Further to your e-mail of 14 October regarding the surface water drainage proposals at the above site and our subsequent discussions please find attached revised details submitted for your approval and to discharge drainage conditions for the planning consent Y/5/17/OUT. From correspondence between the Planning Officer, James Cross and Emma Jones at Crayfern Homes, it would appear that you require further information to discharge conditions 16 & 17.

Consequently the 450mm dia. pipe that was going to connect these ditches has been removed from the proposed engineering design. In addition it has now been possible to rationalise the proposed attenuation on the east side of the site down to a single tank and outfall. Details of this revised proposal can be seen on the attached drawings KNC1826.

D1 Outfall Gully Details

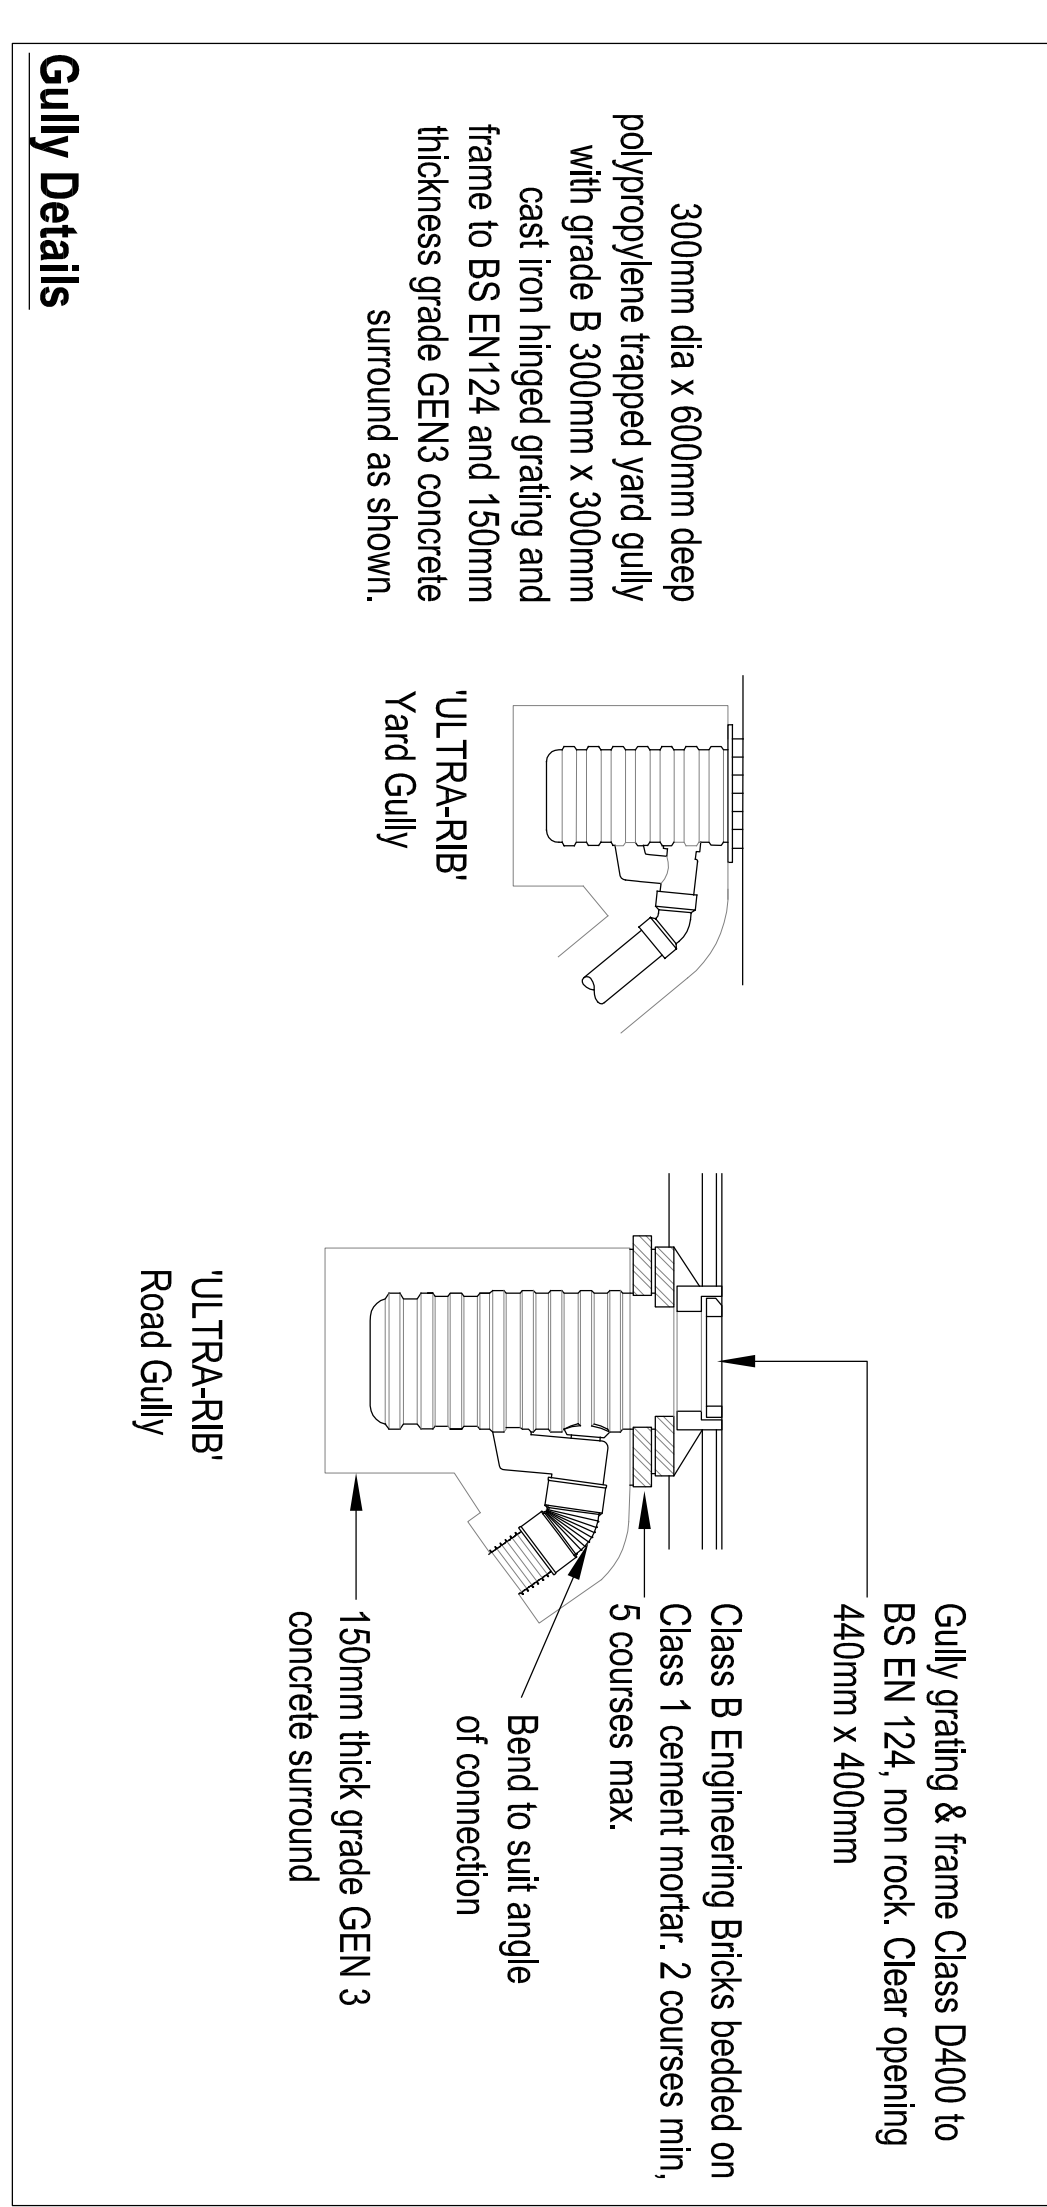
5. Rather than the D1 gully arrangement shown as the ditch outfall, we would like to see a headwall arrangement with sloped grille/sump set back into the bank. See attached photo – not a good example but you can see the principle. Please provide a fully detailed construction drawing. The grille will need to be angled to help reduce the full blockage risk. It should also be hinged and lockable (padlock to be positioned above typical potential water levels to help prevent corrosion).

5. This comment is no longer applicable as the connecting culvert has been removed.
6. As 5. above
7. As 5. above
8. As 5. above
9. The only headwall discharging into the eastern ditch is H1. This has been re-positioned slightly down stream from the original intention. Unfortunately there is no scope to raise the outfall level from H1 into the ditch. Re-grading levels have been provided.

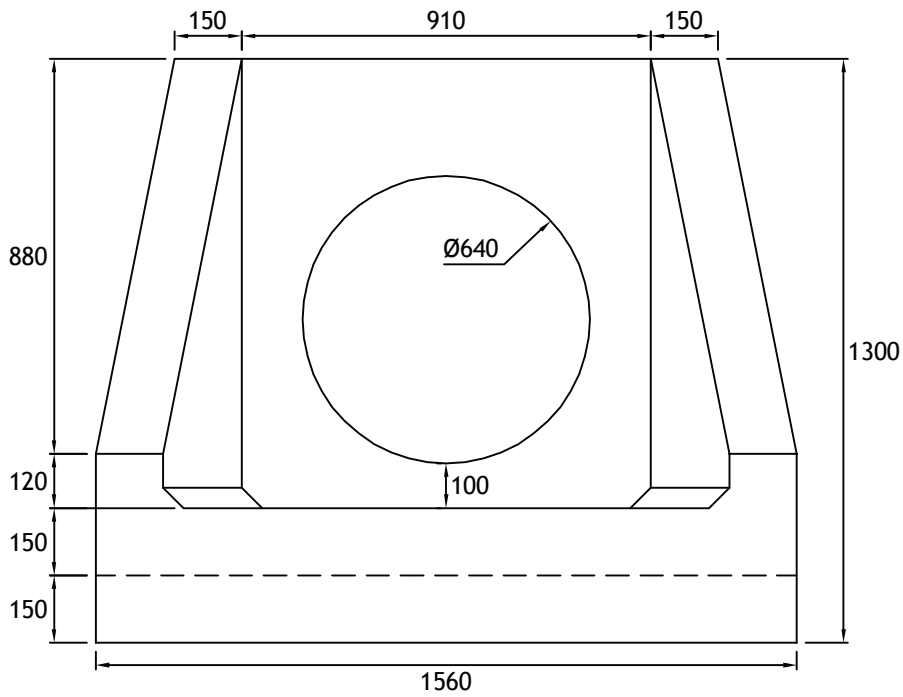
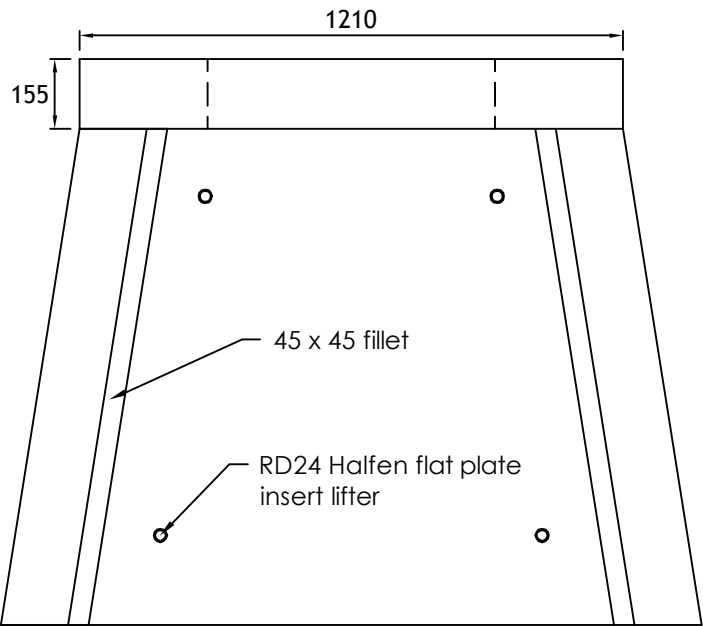
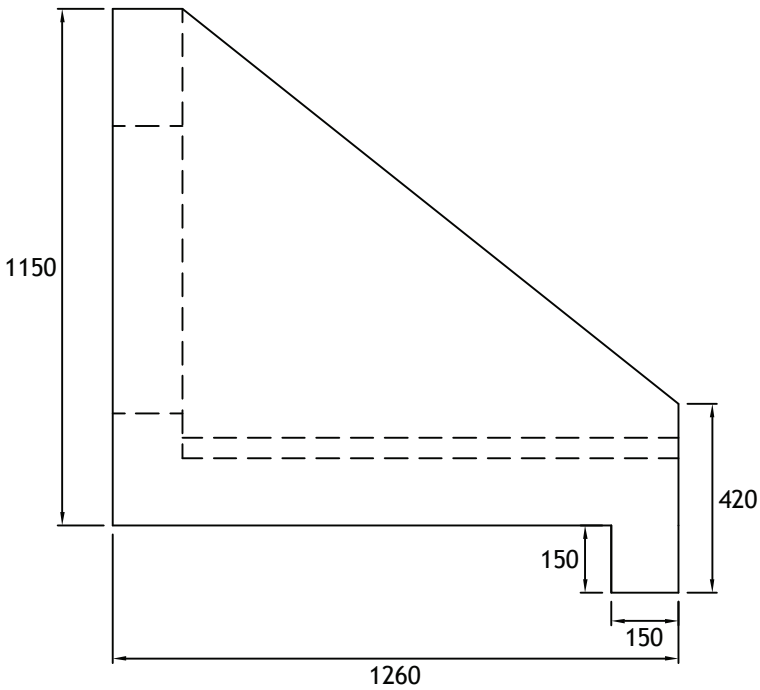
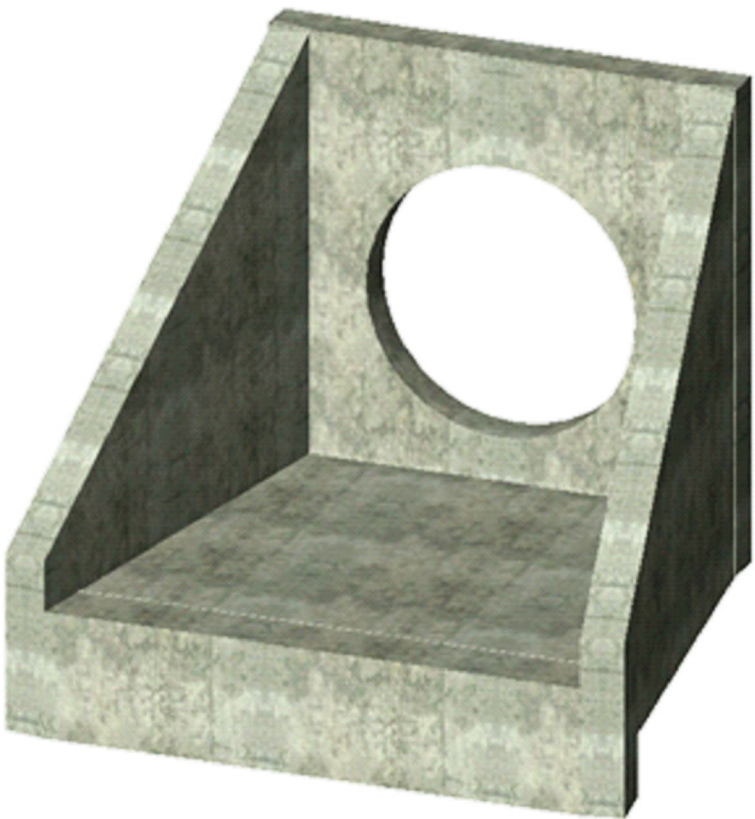
3. Specify invert level of headwall H4. Provide construction detail.
4. I note a number of gullies being connected to the ditch (unattenuated). Has this been agreed during the planning process? If so, please specify invert levels, headwall details.

11. Manhole D6 can be omitted, unless there is a good reason for it to be retained.
12. The proposed headwall detail for outfalls H1 to H3 needs a bit more detailing, and to include mesh reinforcement in the aprons. See attached drawing for guidance. Please also include a section through the detail on the detailing. Erosion control measures may be required and should be detailed as required.
13. Provide a site location plan (scale 1/1250).
14. Application Fees will be £300. I have reduced the actual fee since you are providing significant betterment to the current land drainage situation on/off the site.

3. Invert levels have been identified for manholes H1 & H4. It is proposed to install precast headwalls rather than construct in-situ brick or concrete. Attached is a copy of the plan of the Tracey Concrete headwall that it is proposed to install where a headwall is required. Should you require grills to be installed these can be fixed to the wingwalls. As all the headwalls are outfalls rather than inlets is it going to be a requirement to install grills?

10. As 5. above
11. As 5. above
12. For ease of construction it is proposed to use a precast headwall. The proposed headwall is manufactured by Tracey Concrete and their standard detail and specification is shown on the attached drawing. as you will note there is an erosion control downstand incorporated into the spillway and if required a grill can be fitted to the wingwalls if access prevention is required.
